From: [REDACTED]
Sent: 22 July 2026 17:33
To: Sally Robbin [REDACTED]
Subject: 16568/APP/2026/703- Holland and Holland

Please find below TfL's comments on planning application 16568/APP/2026/703.

PROPOSED SITE LAYOUT

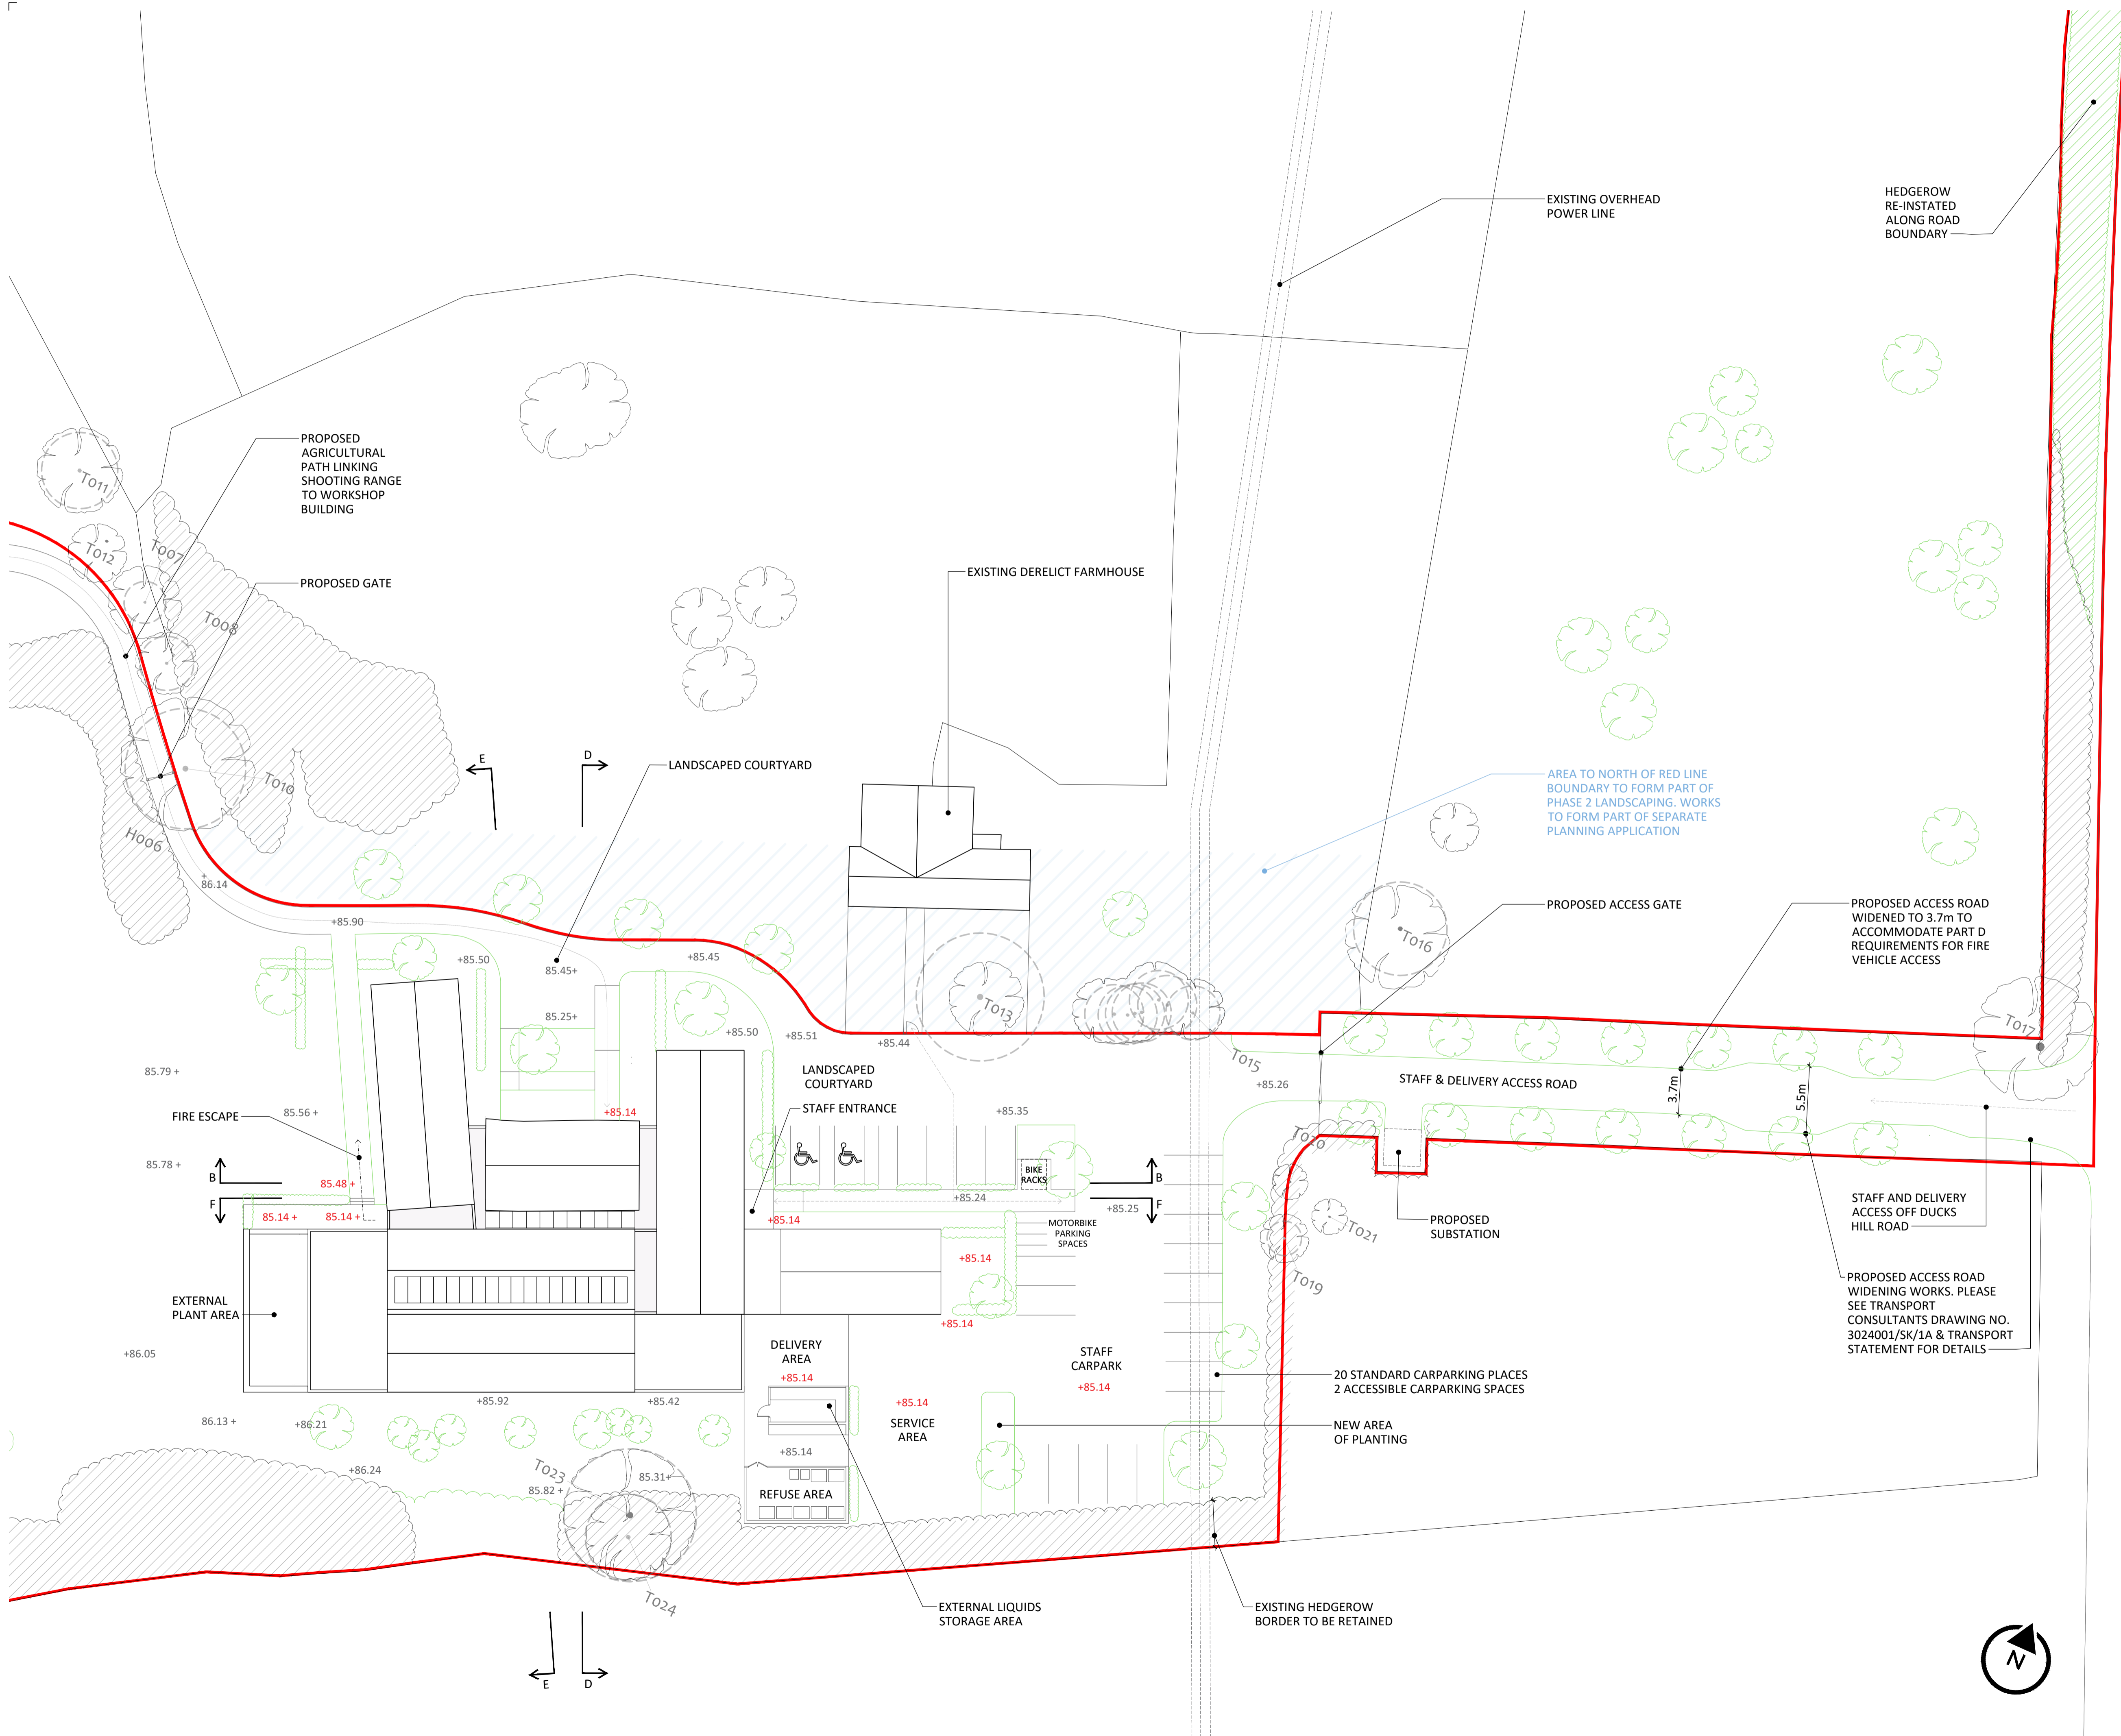
Amendments are proposed to the vehicle access to this site. A Stage 1 Road Safety audit should be undertaken, with this being reviewed by the relevant highway authority and any concerns raised satisfactorily addressed.

A total of 26 parking spaces – comprised of 22 parking spaces and 4 motorcycle parking spaces – is proposed. This level of parking appears excessive when compared with the anticipated number of employees and the site, and should, therefore reduced. Further, the proposed level of parking should be seeking to support a modal shift in line with Policy T1 of the London Plan. Noting the aforementioned, the level of parking at this site should be reduced.

The level of disabled person parking provision at this site should be confirmed. This should be in line with London Plan standards.

The Transport Assessment states that 5% of the parking spaces will have passive provision and 5% will have active EVCP provision. However, it is noted that the planning application form for the site says that no electric vehicle charging provision is being provided. EVCP should be provided in line with London Plan standards.

The level of cycle parking to be provided at this site has not been stated, as such TfL is unable to confirm whether it is in line with London Plan standards.
